From: Carl Moore 
Sent: 20 June 2018 11:37
To: Andrew Wood; Juan Baeza
Subject: FW: FG/95/18/HH - 25 South Drive, Ferring

I refer to the current planning application for a proposed 2 storey extension at the front of 25 South Drive in Ferring (FG/95/18/HH).

AR-102-202/A

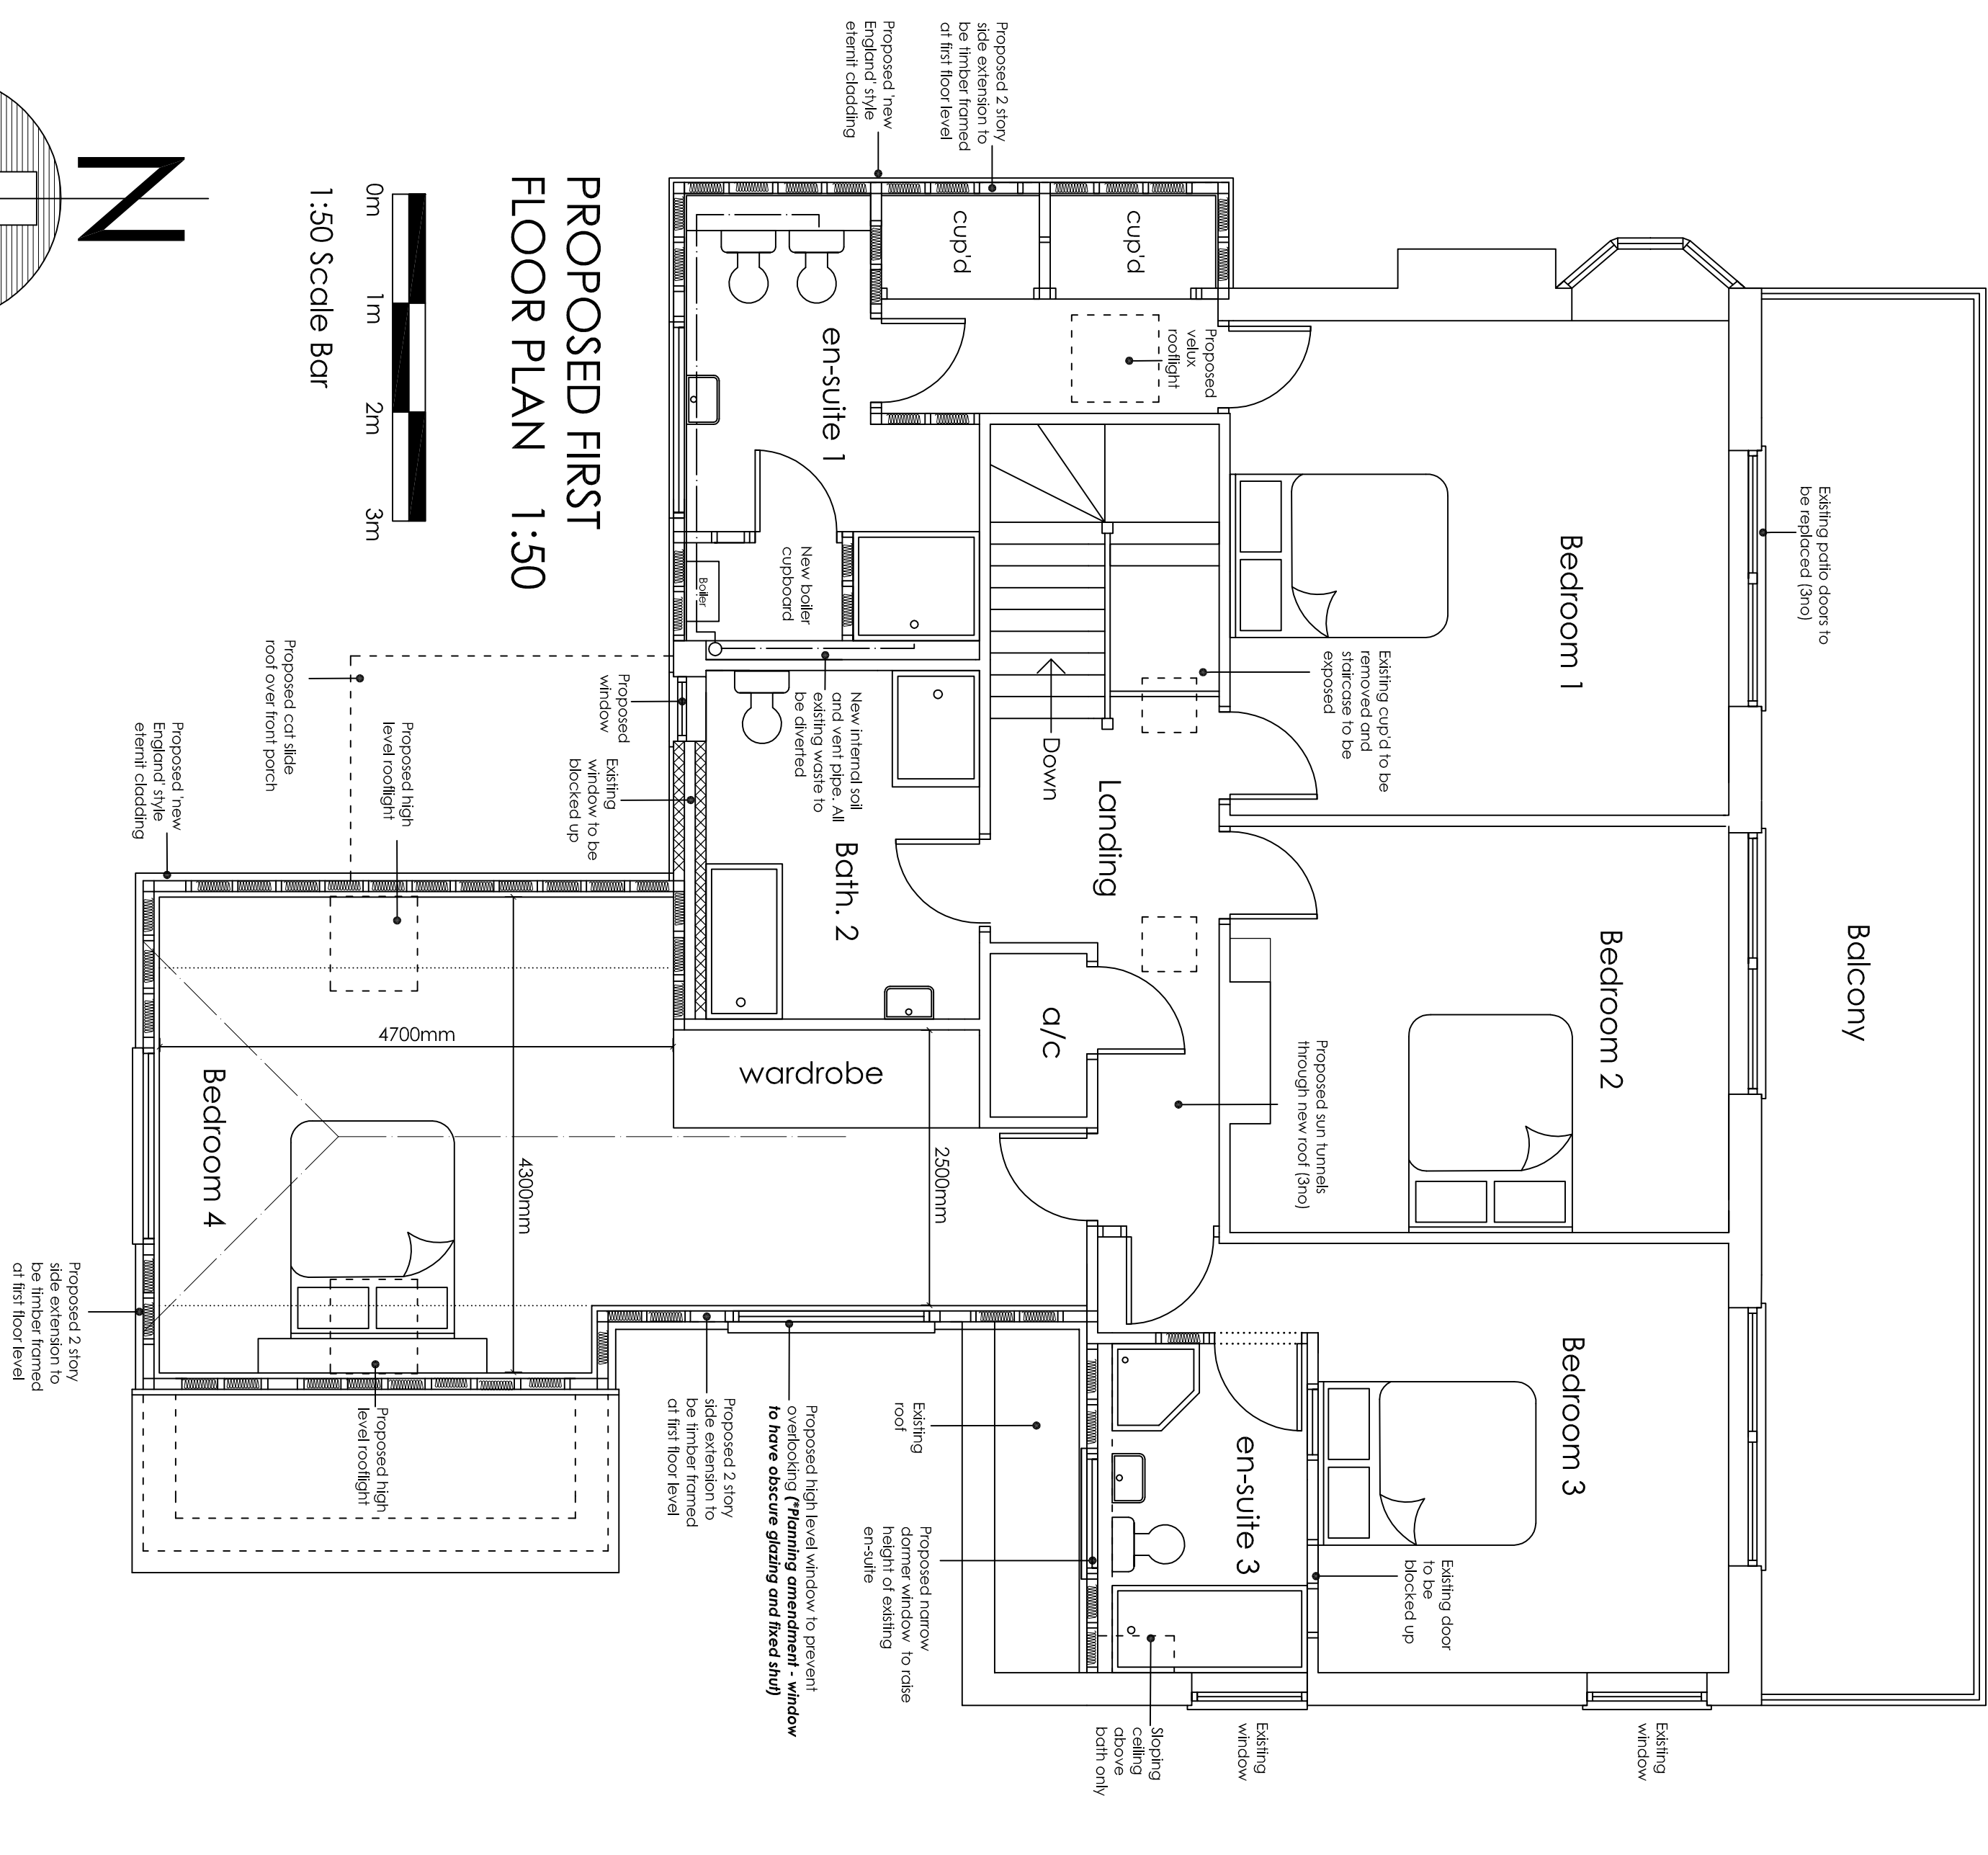
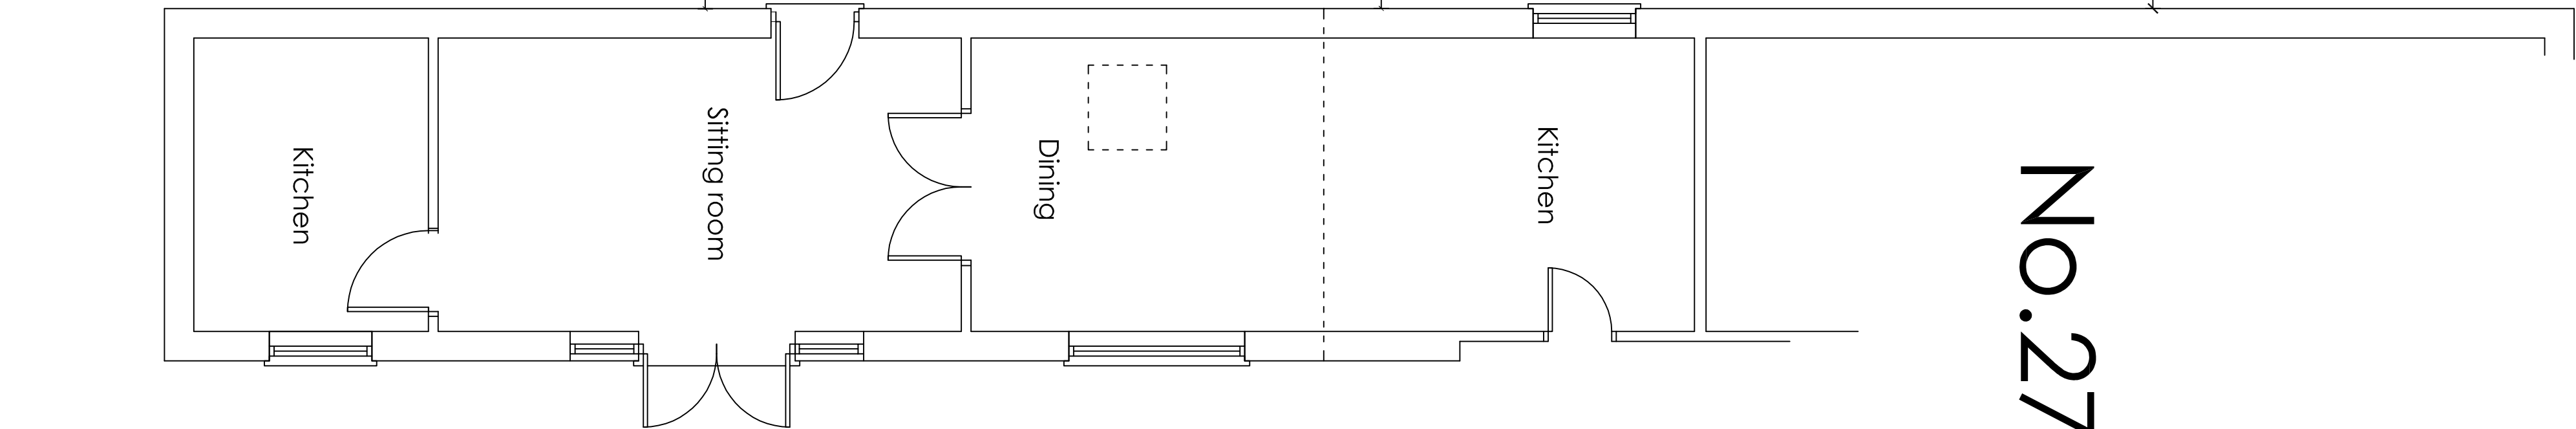
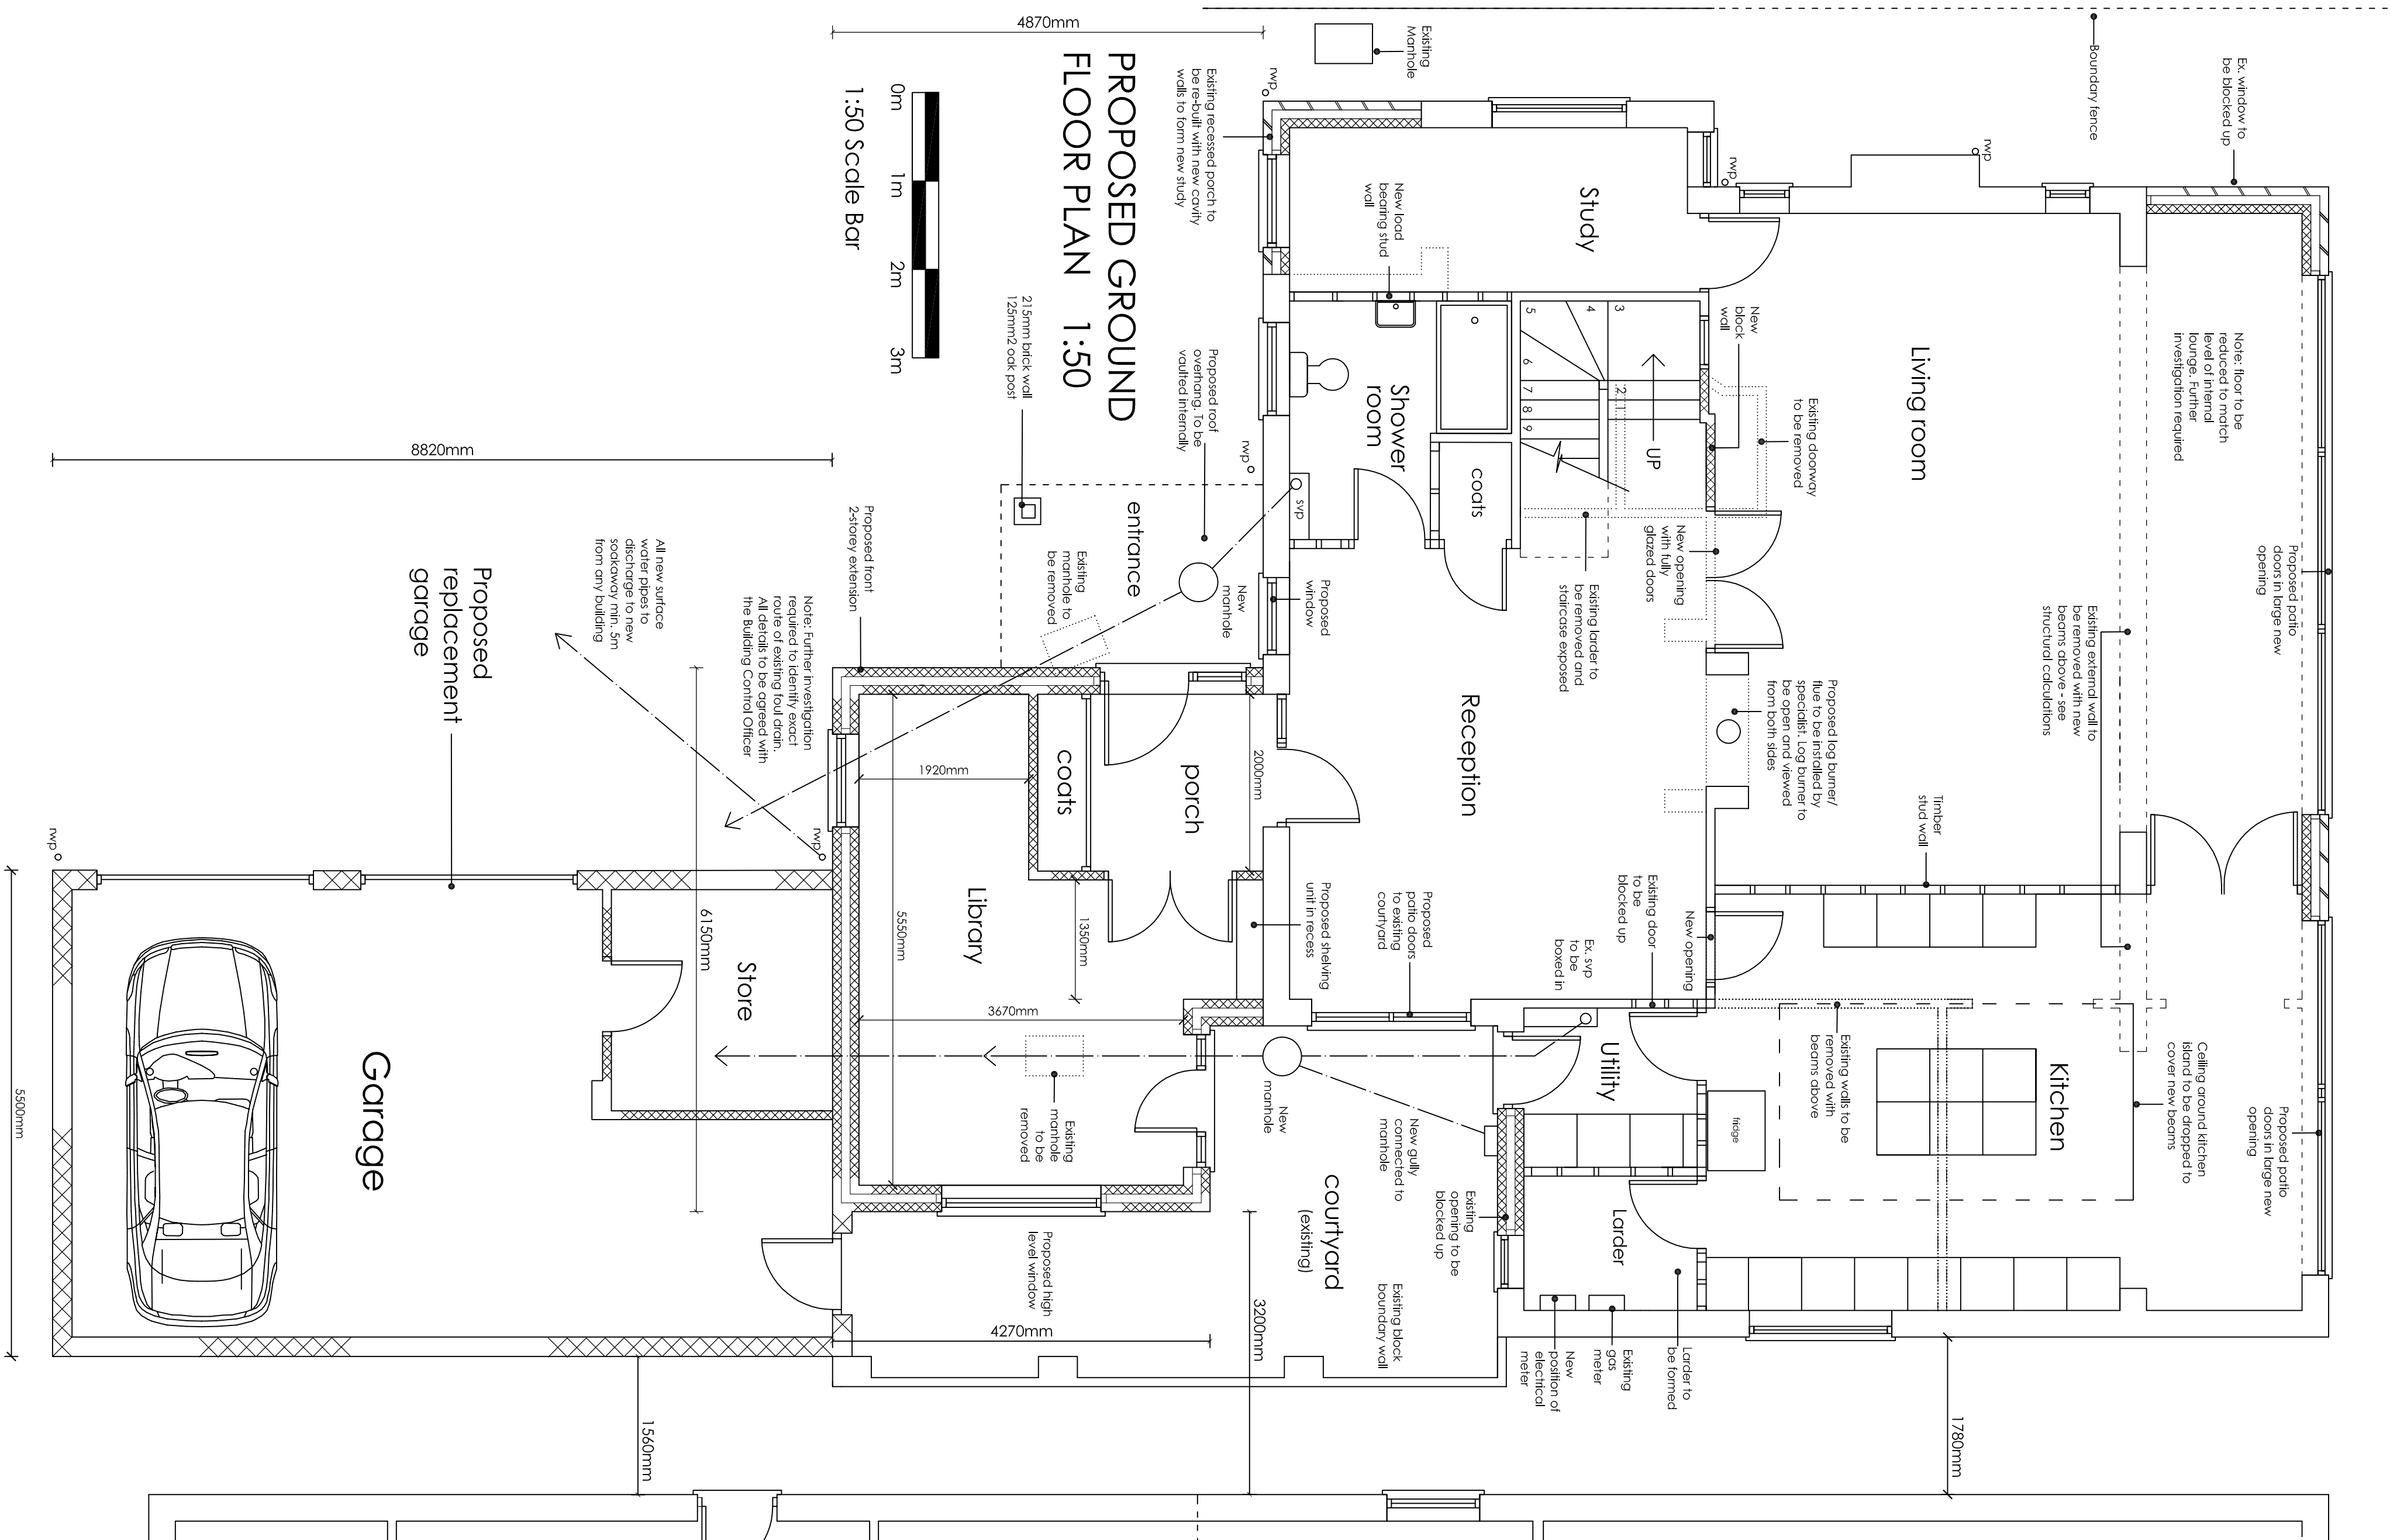
I understand that the neighbour at No.27 has submitted an objection with regard to the high level window on the west elevation. As suggested by the neighbour the client has agreed to obscure this window and ensure that the window is non-opening at all times. I have therefore attached amended drawings and included a note to confirm this suggestion. If the application is approved then please could you include a planning condition to cover this point.
